# Householder Proforma

**Application Ref:** 2023/0314

**Address:** The Dairy, Cockle Edge, Huddersfield Road, Ingbirchworth, S36 7GF

**Proposed:** The proposal is for the erection of a single storey rear extension to the dwelling forming a boot room and sitting room. The boot room will project 4.35m and measure 1.88m in width, 2.65m to the eaves, 2.75m total height and the attached sitting room will project 3.05m, measure 5.90m in width, 2.58m to the eaves and 2.73m total height. The boot room will be built in matching stone and the sitting room will have a fully glazed elevation of sliding doors. The entire extension will have a flat roof and the boot room will have a side facing high level window.

Client Mr P Cadman  
Project 2327 - Cockle Edge Farm : Home Extension  
Title Proposed Site and Ground Floor Plans

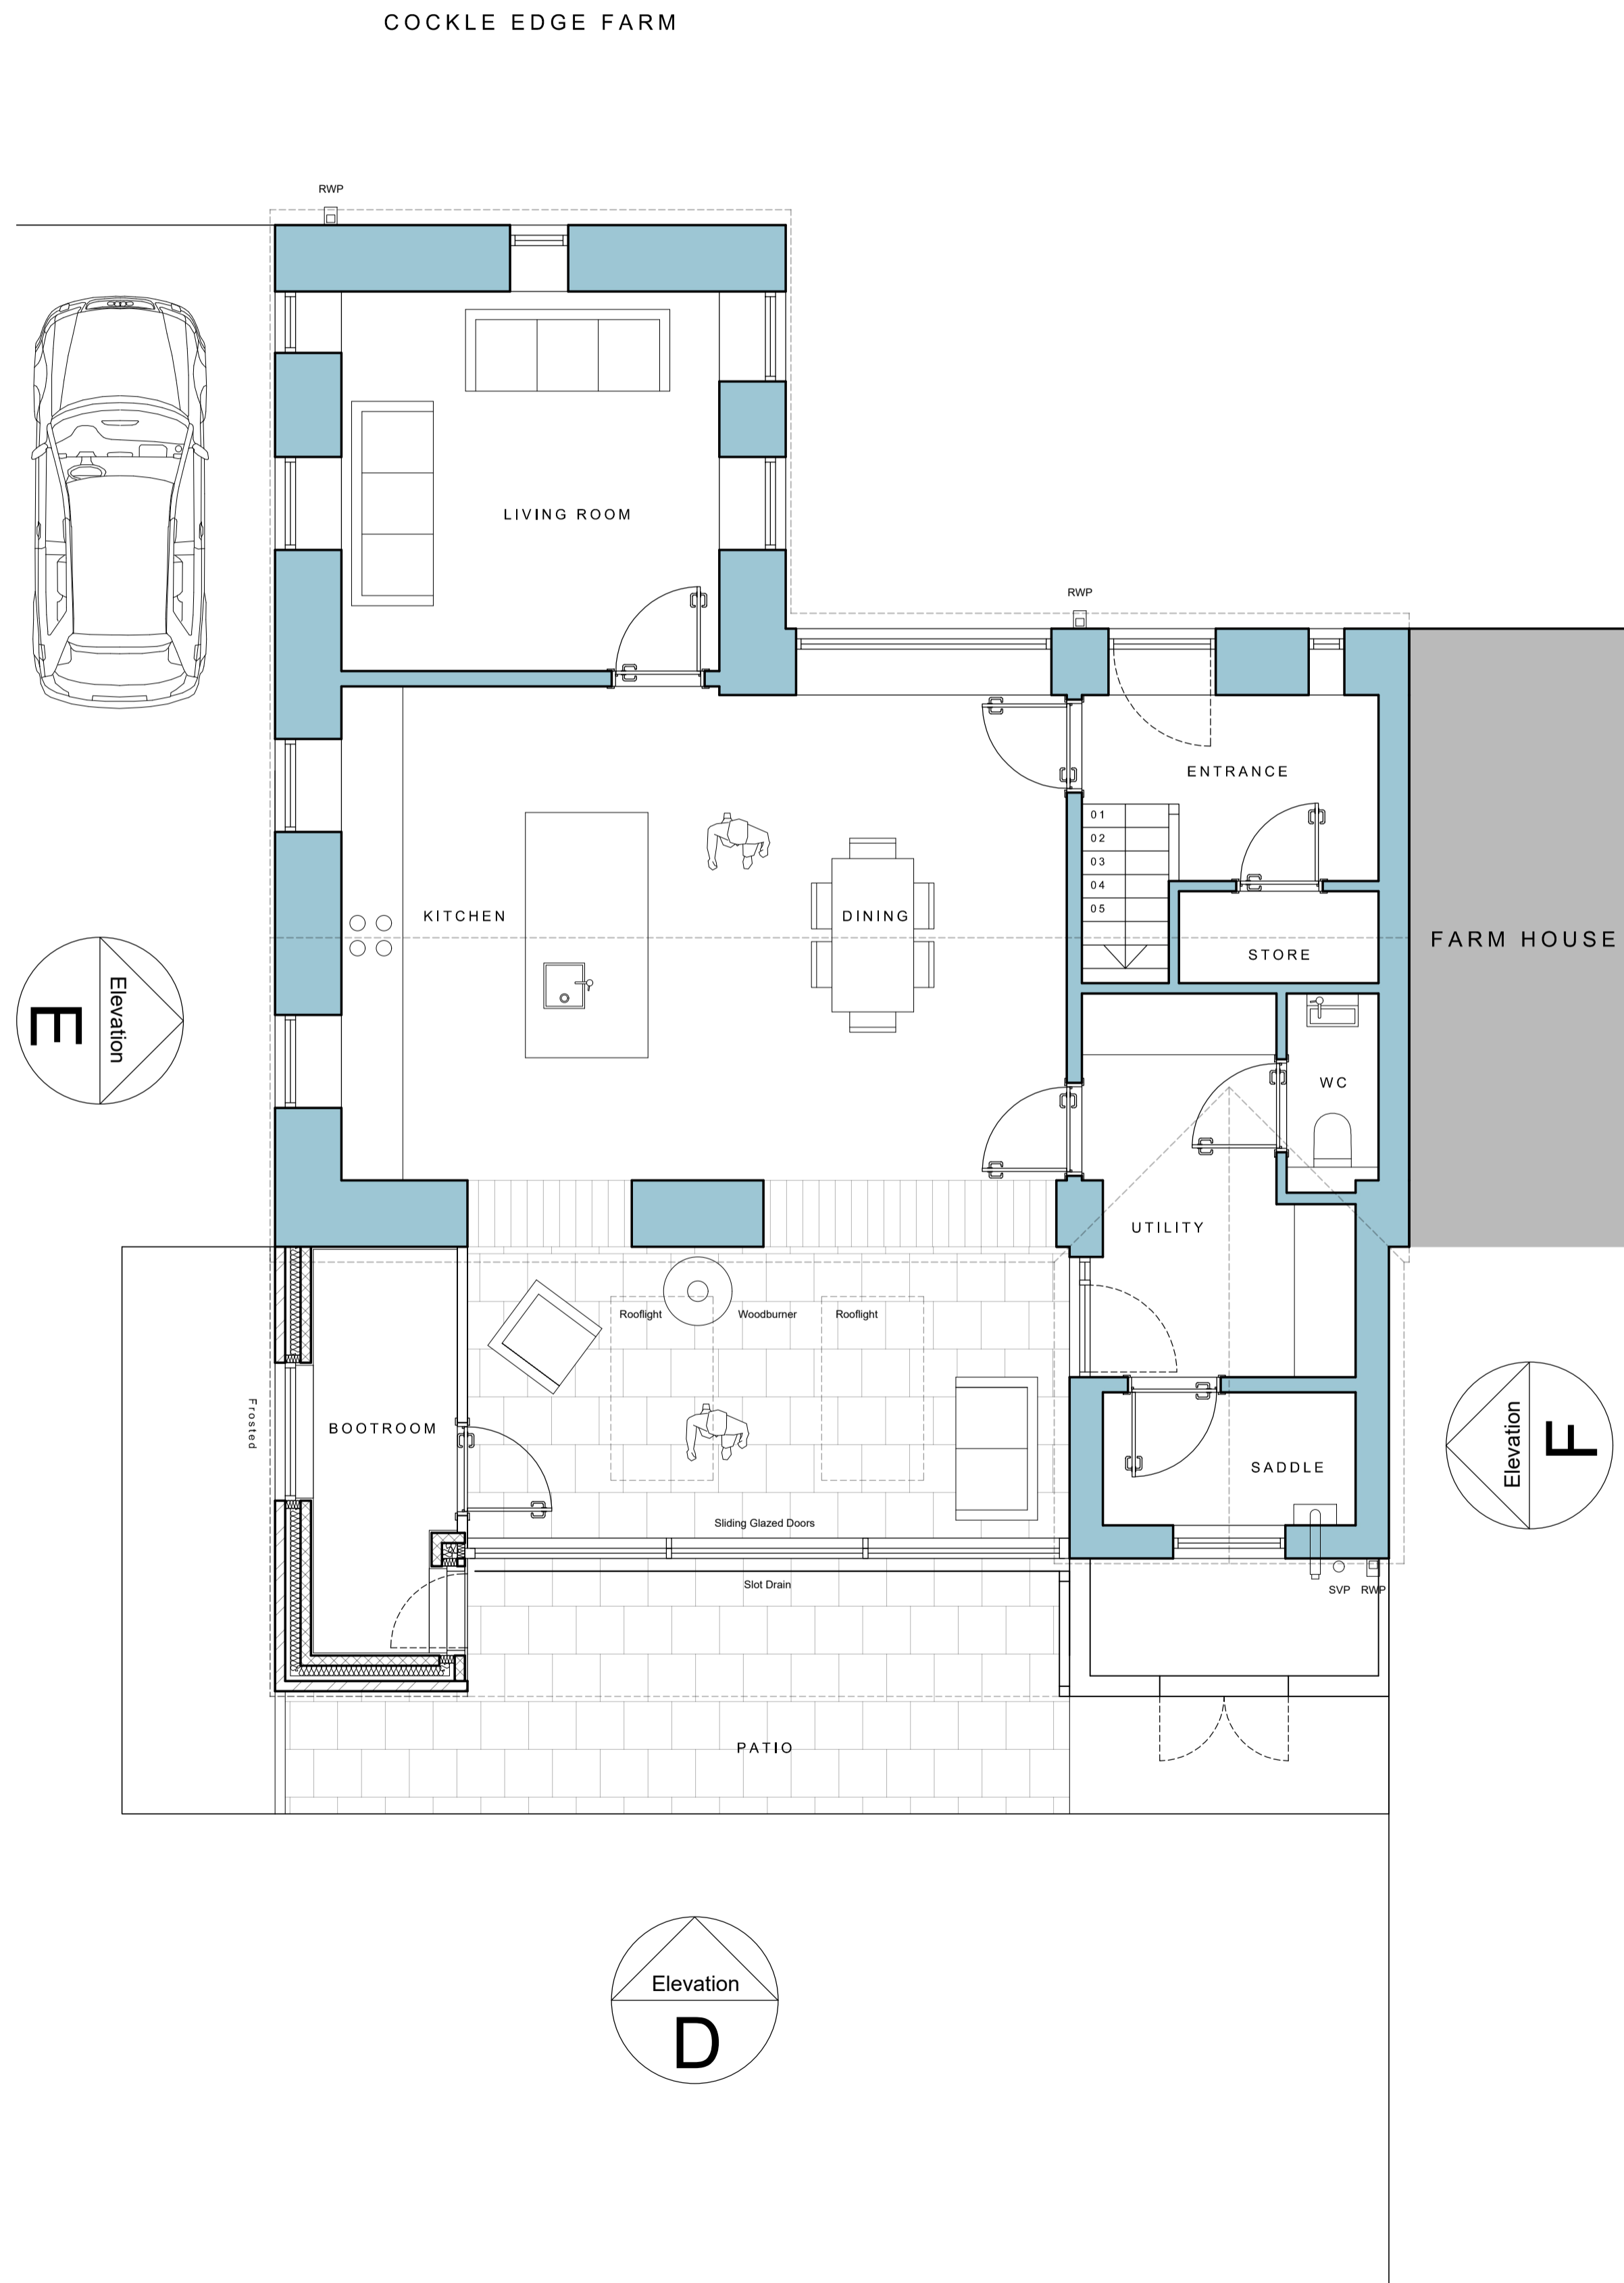
The application also proposes another small flat roofed extension providing a store. This will be built on the existing two storey timber clad projection and will continue with matching timber clad

materials. Double doors will face into the rear garden. This extension will project 1.35m and measure 3.13m in width, 2.73m total height.

Measurements
1. Original dwelling	143.7m <sup>2</sup>
2. proposed extensions	Boot room and sitting room 26.17m <sup>2</sup> Store 4.22m <sup>2</sup>
3. any existing extensions (the lean-to extension may not be modern but included it in here just in case)	Two storey rear extension 16.8m <sup>2</sup>
4. total extensions (including proposed)	47.19m <sup>2</sup>
